MINUTES

Meeting	Locomotive Workshop – Mod 7 (Innovation Plaza)
Venue	Microsoft Teams
Time	4:00pm
Date	18 August 2021
Chair	Pip Williams
Attendees	Phillipa Williams (Mirvac Projects) Long Nguyen (Mirvac Projects) Nathan McCoy (Mirvac Projects) Tom Waters (Mirvac Projects) David Nix (Heritage NSW) Hendry Wan (Heritage NSW) Andrew Rees (City of Sydney) Priyanka Misra (City of Sydney) Claire Burdett (Ethos Urban) Natalie Vinton (Curio Projects) Tatiana Barreto (Curio Projects)

1 PROPOSED - SOUTH ELEVATION - RETAIL
1 : 250

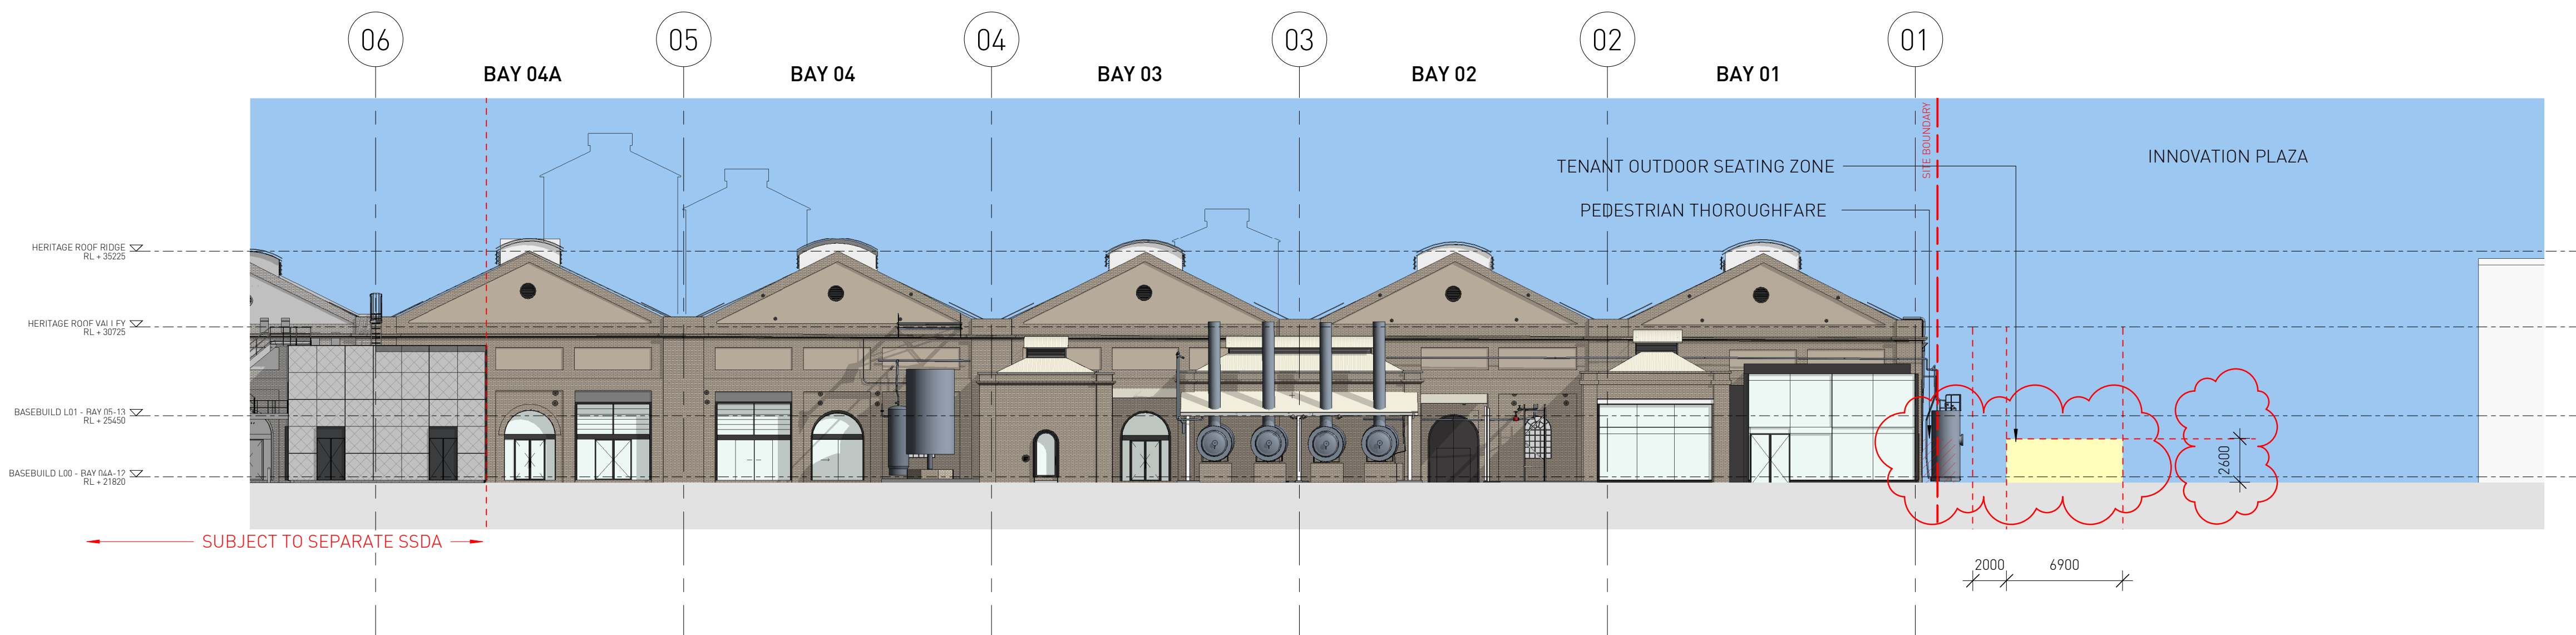
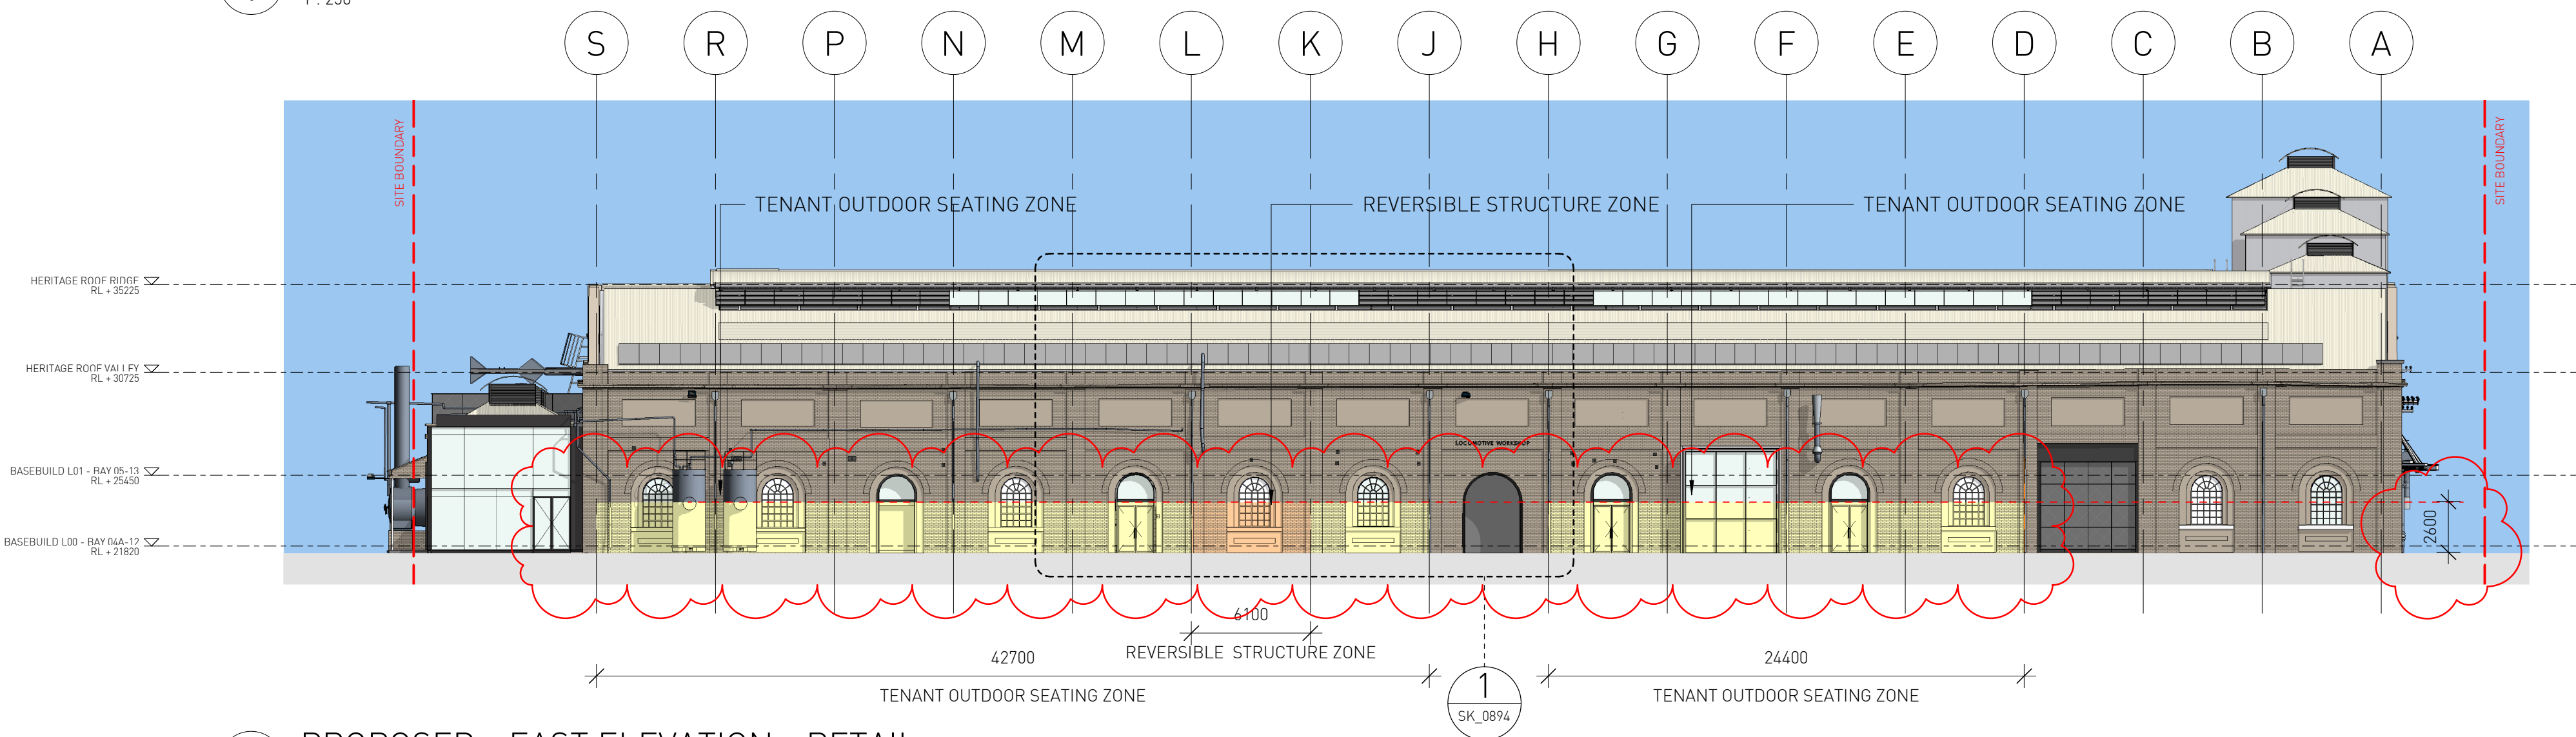
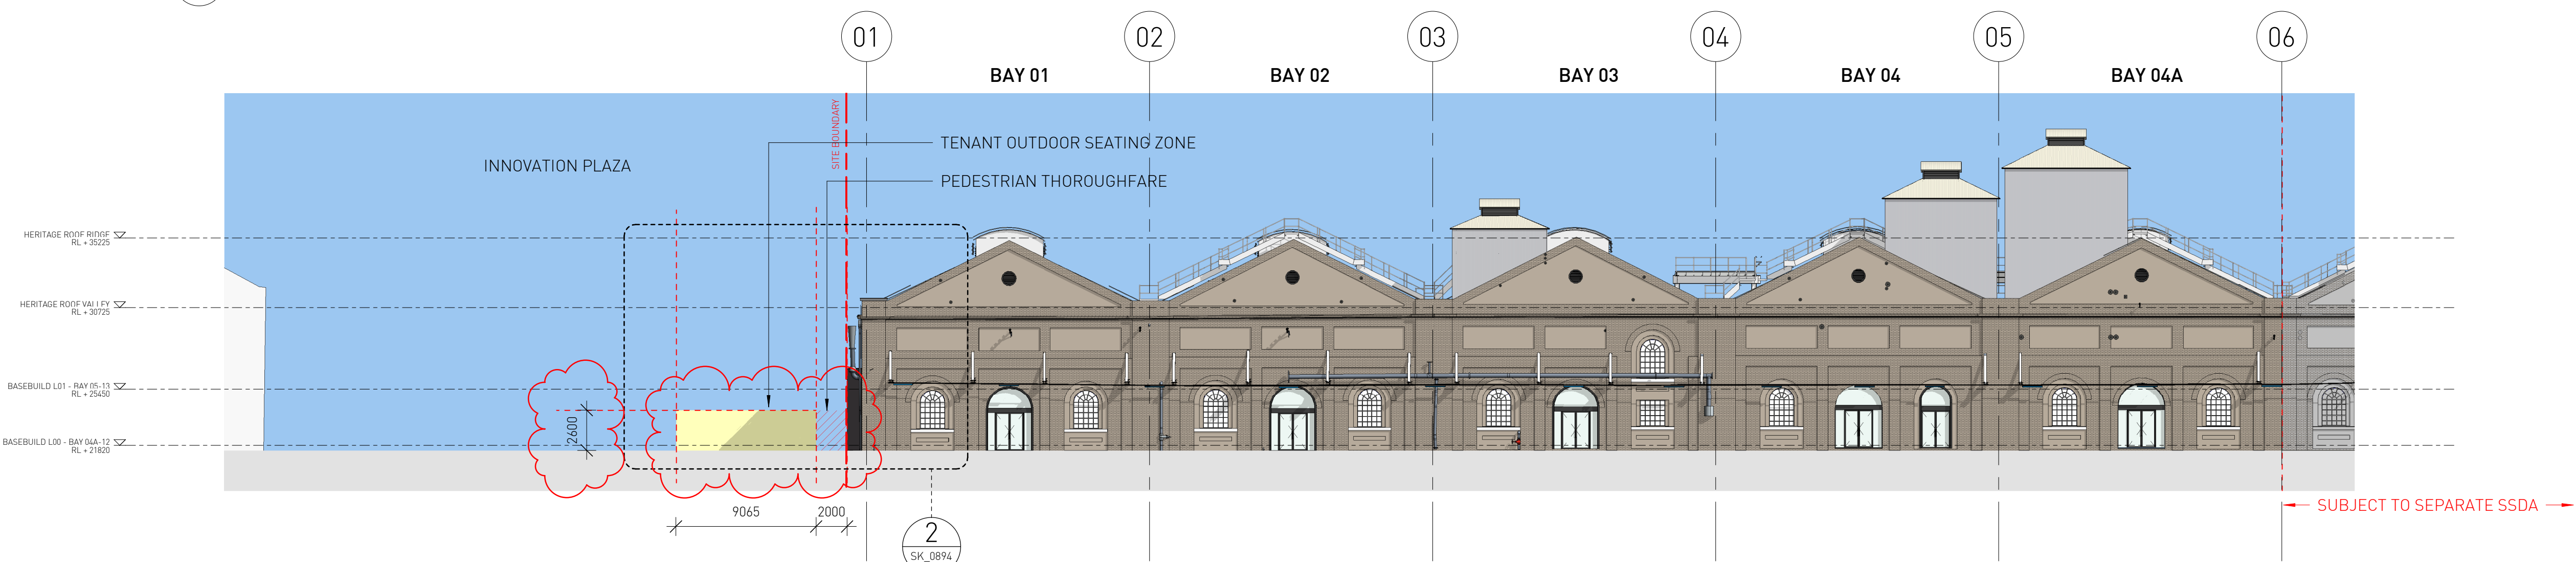
| 3.2 | PM noted the visual impact has been reduced, however queried whether the height of bar structure envelope has been reduced. PW confirmed the height of the envelope has been reduced and will be shown clearly on the modification drawings. | NM |
